3 Pleasant Ave Amendment App & Fast Track

From: John Shields <jshields1@maine.rr.com>
To: "Laurie Leader" <lr@portlandmaine.gov>
Cc: "Bob Gaudreau" <Bob@hardypond.com>
Date: Mon, 23 May 2016 12:31:01 -0400
Subject: 3 Pleasant Ave - Revision No 4

- 1 ELECTRICAL PANELS.
- 2 GAS BOILER & WATER HEATER.
- 3 SPRINKLER ENTRANCE.
- 4 SEWER OUTGO.
- 5 BRICK COLUMN (TYP.)
- 6 DOMESTIC WATER ENTRANCE.

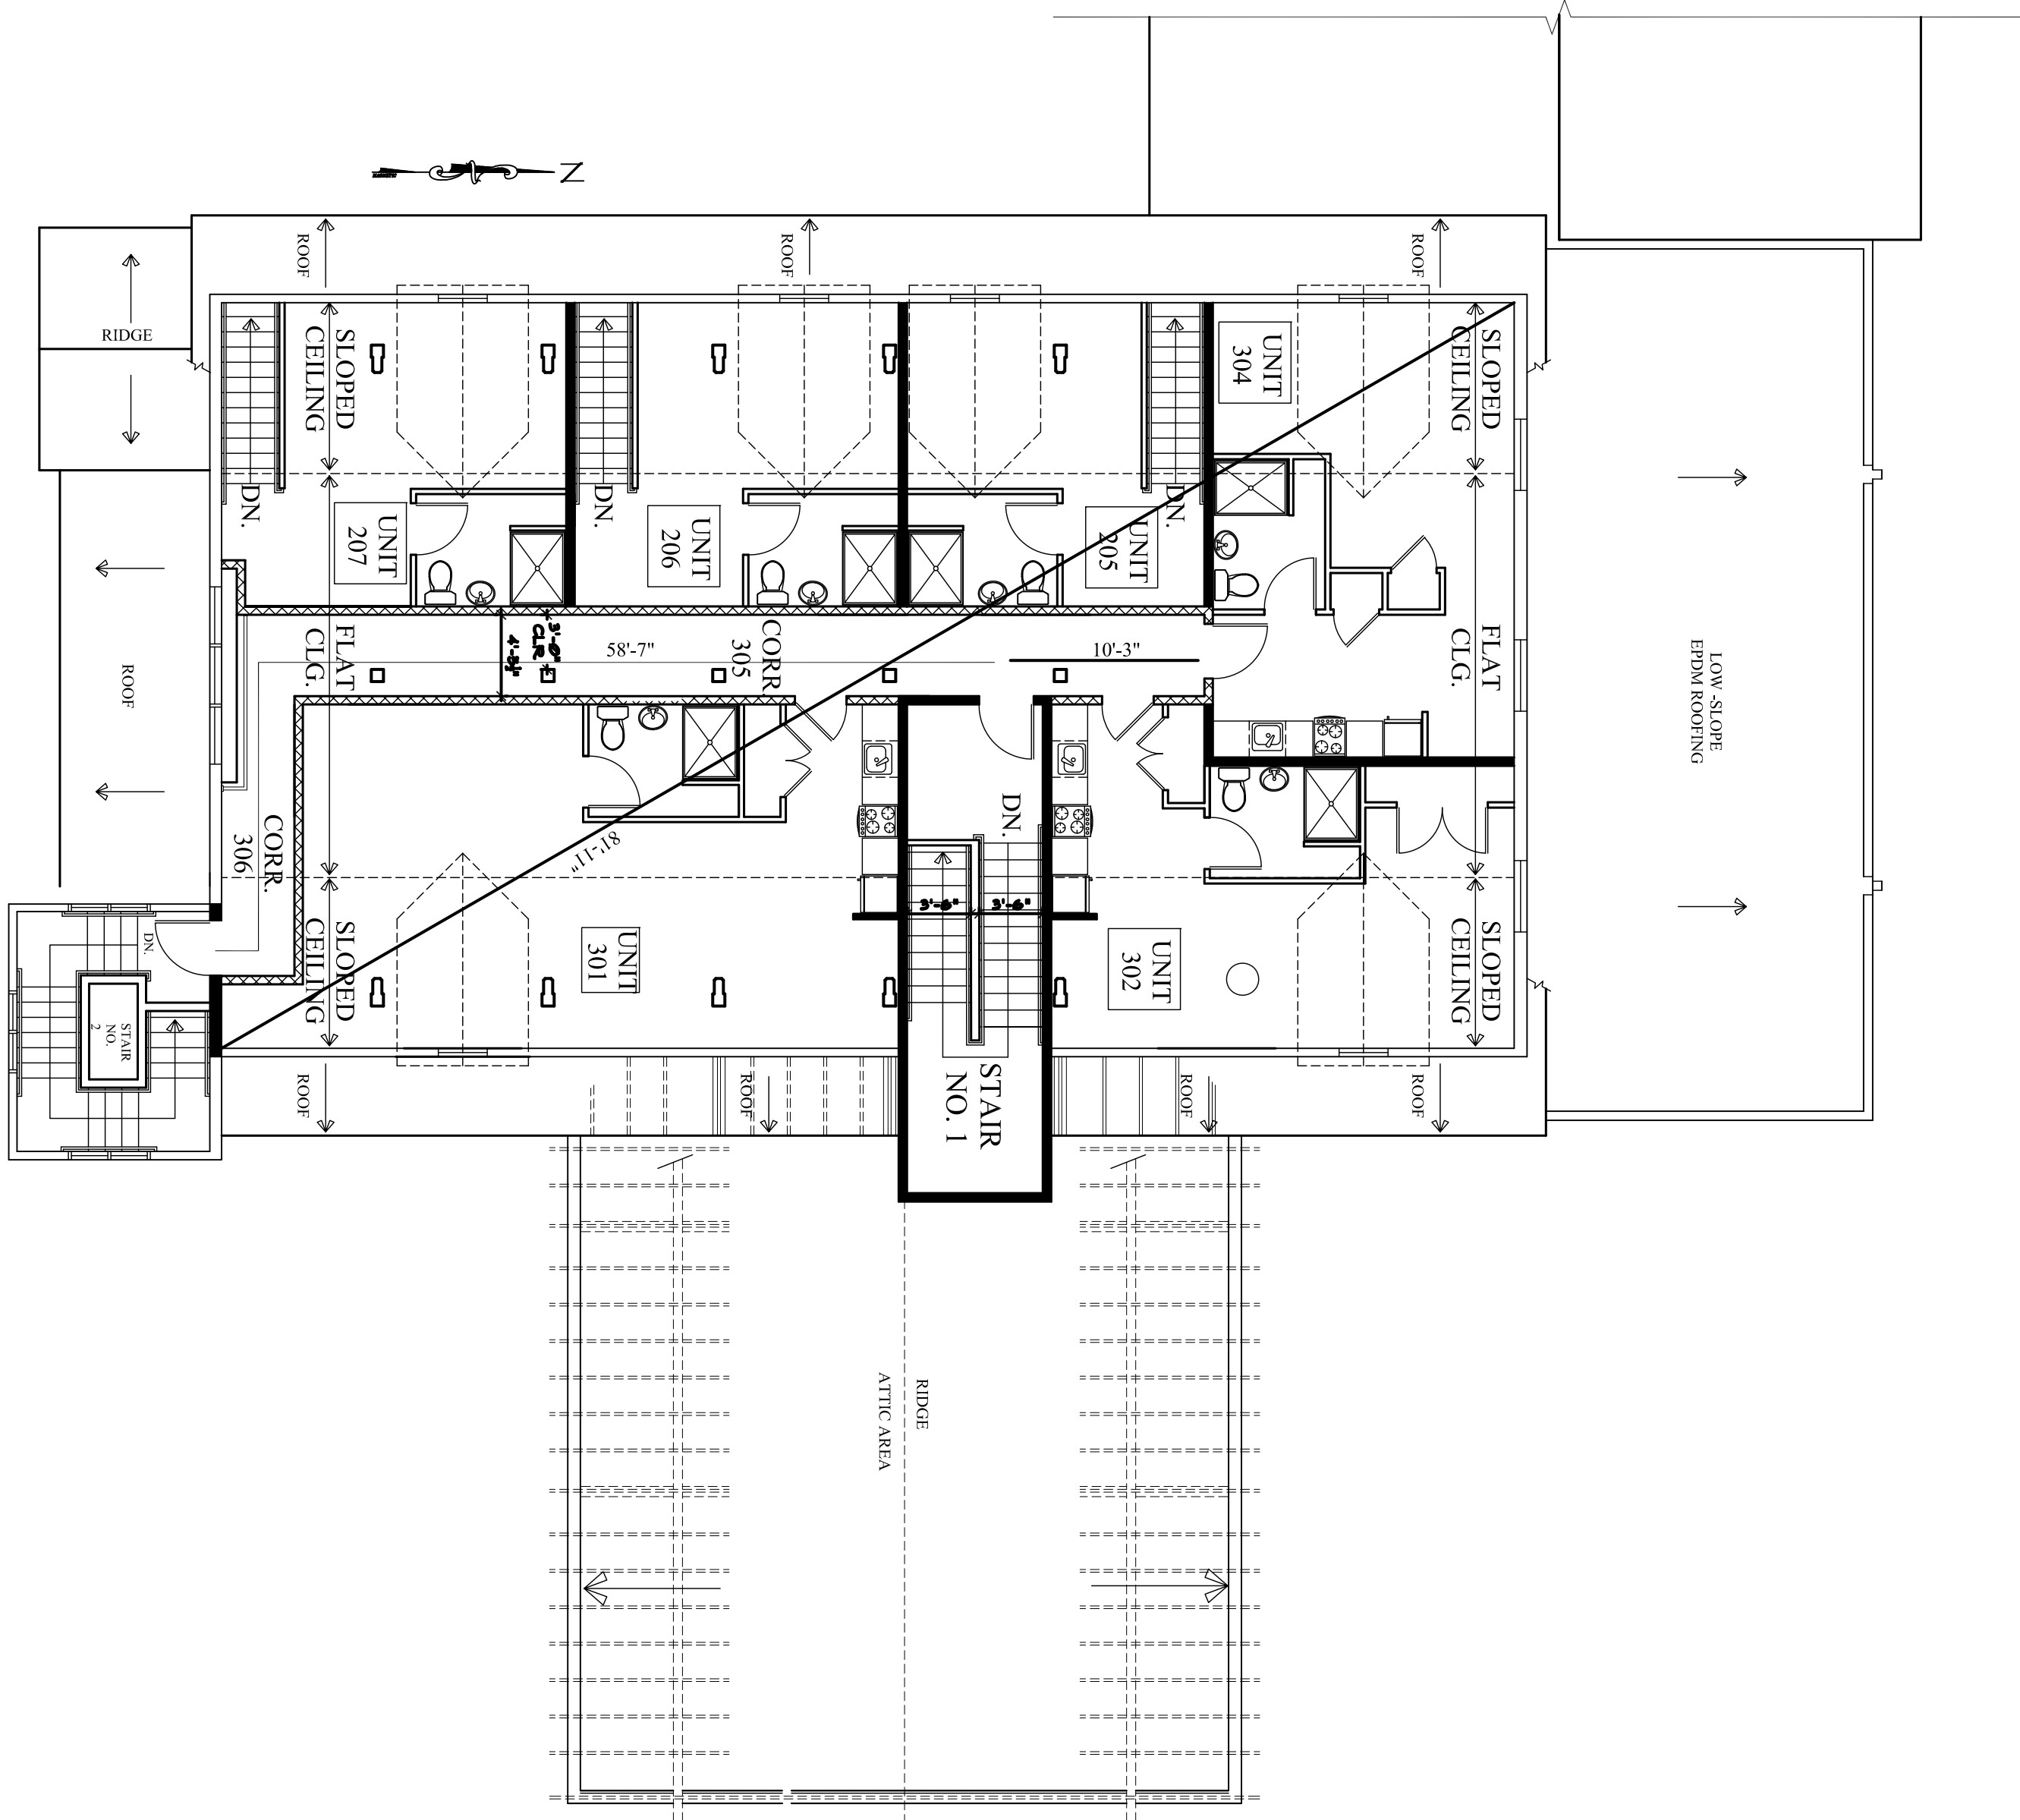
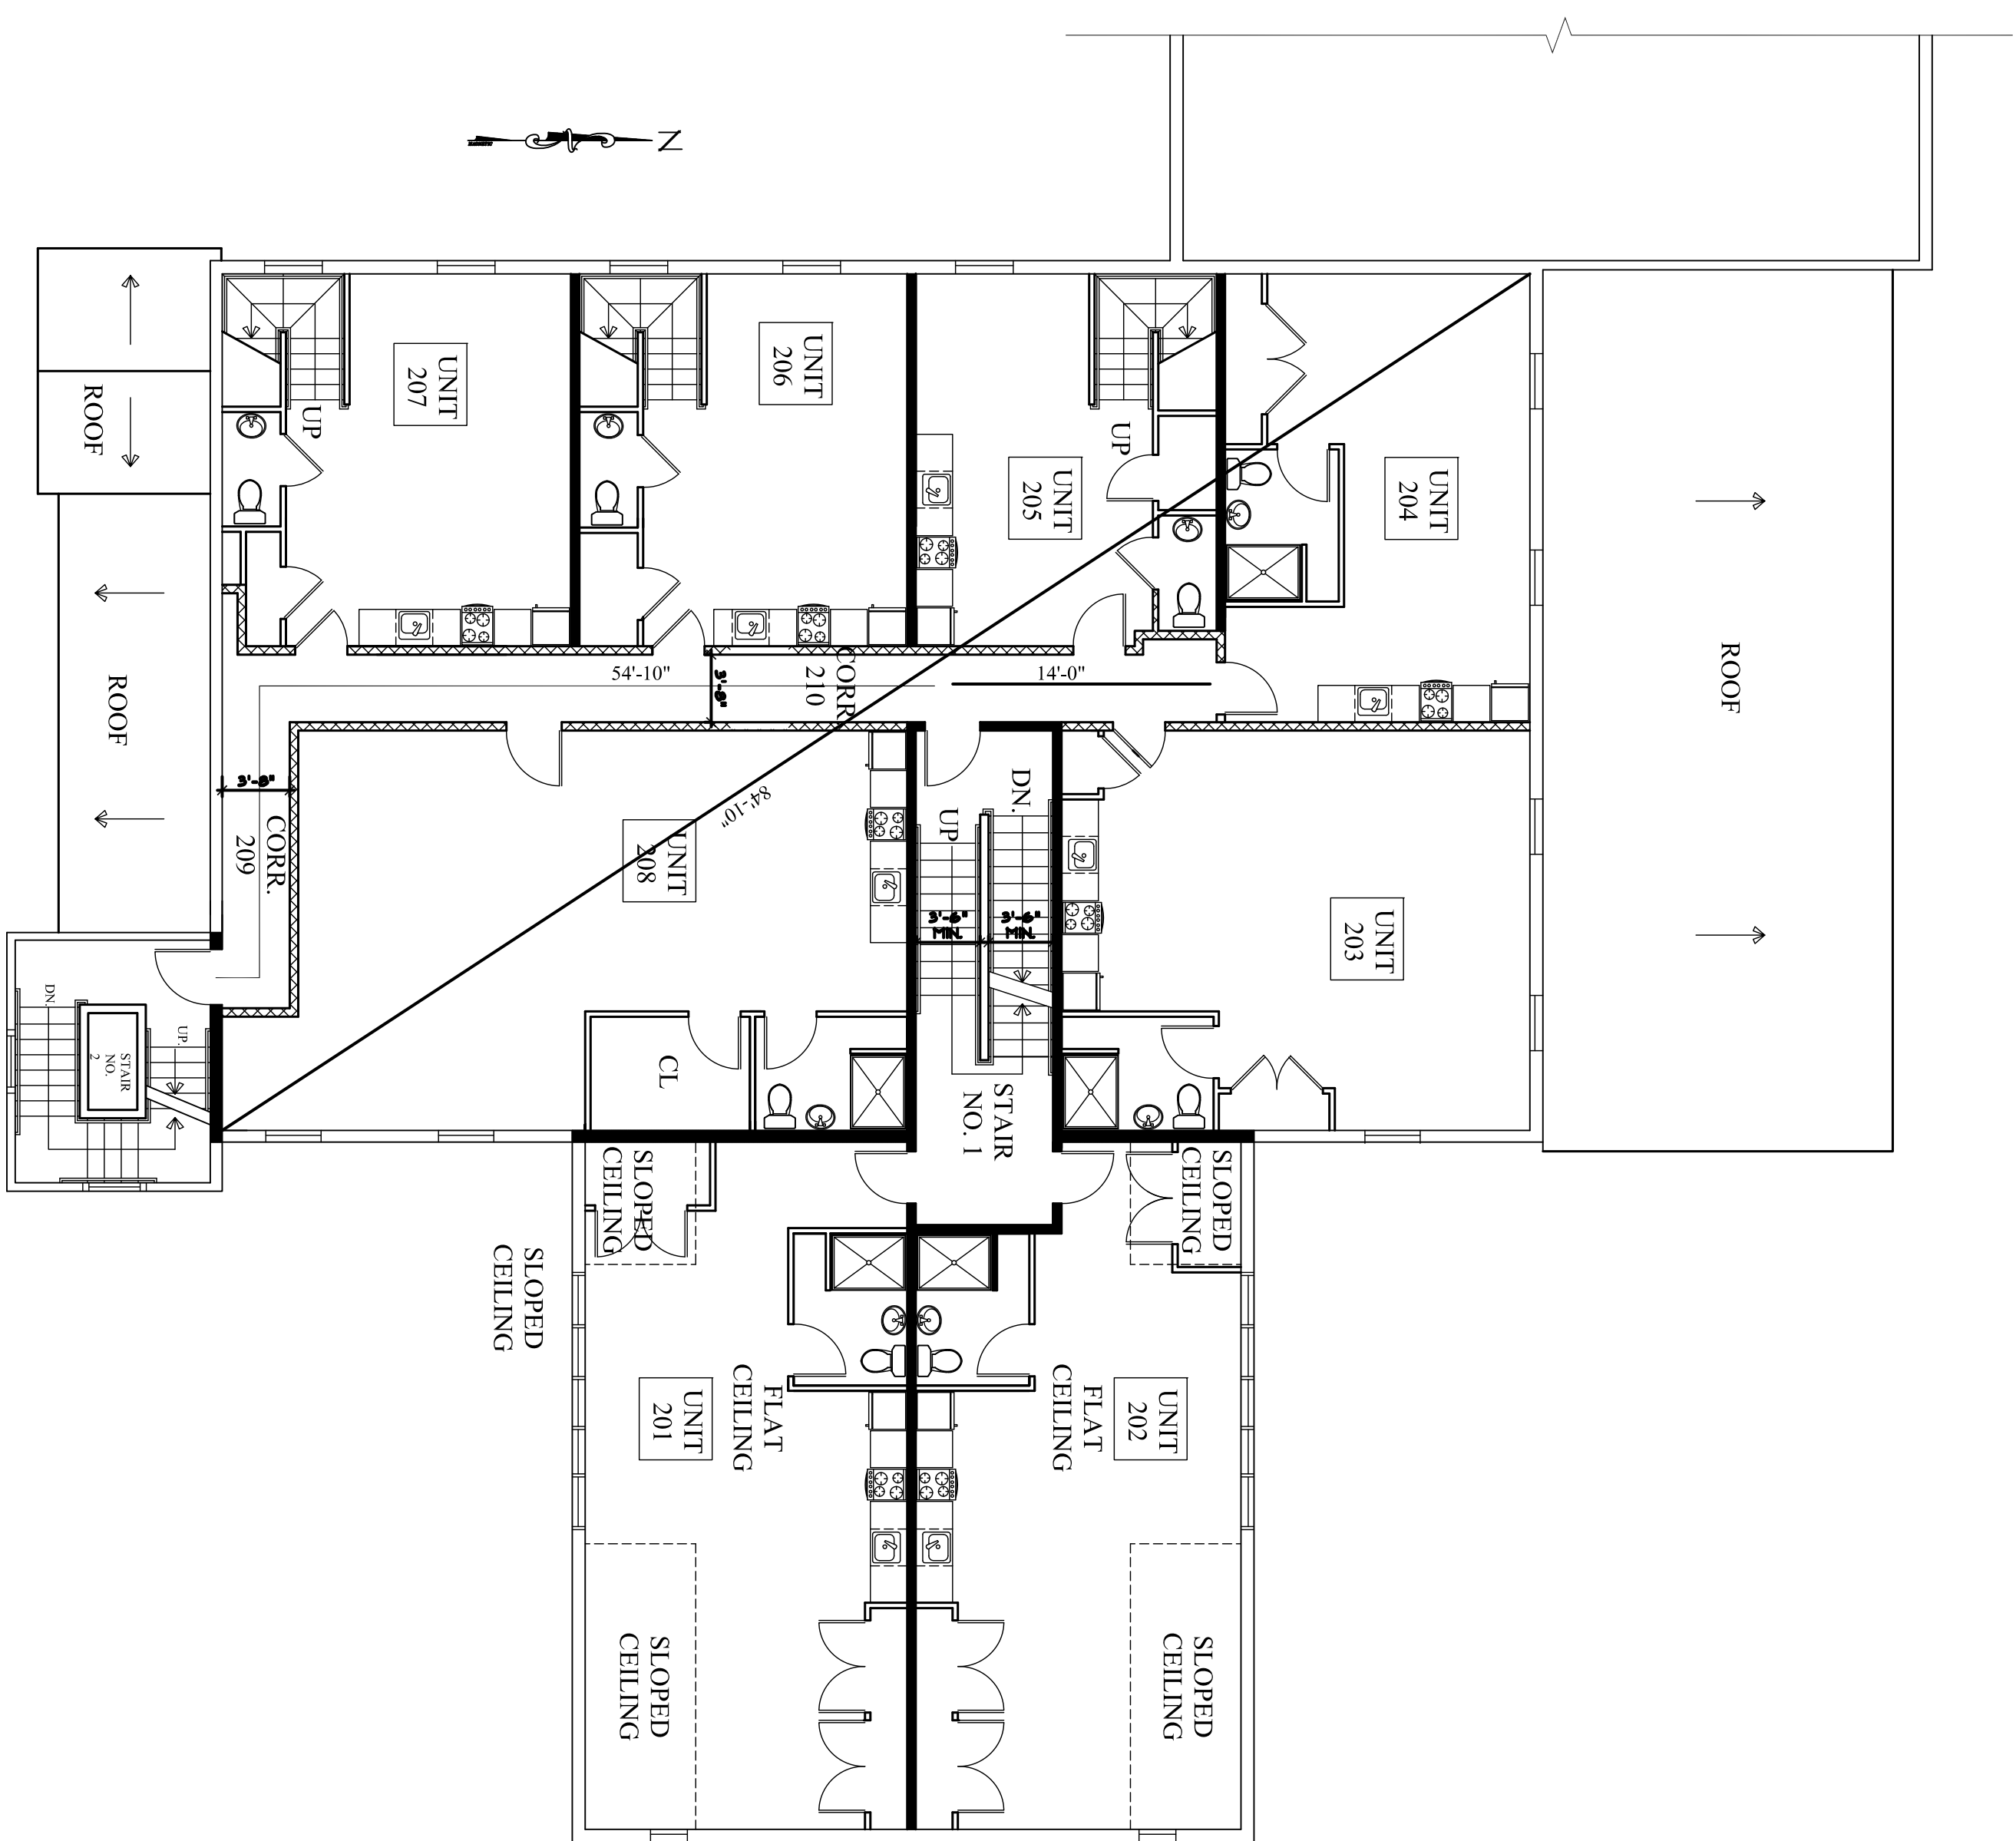
10. Drawing A-16 Fire Alarm & Smoke/CO Detector Plans: Basement Plan revised to show Mechanical Room 008 location.
11. Drawing A-17 Life Safety Plans: Basement Plan revised to show Mechanical Room 008 location.
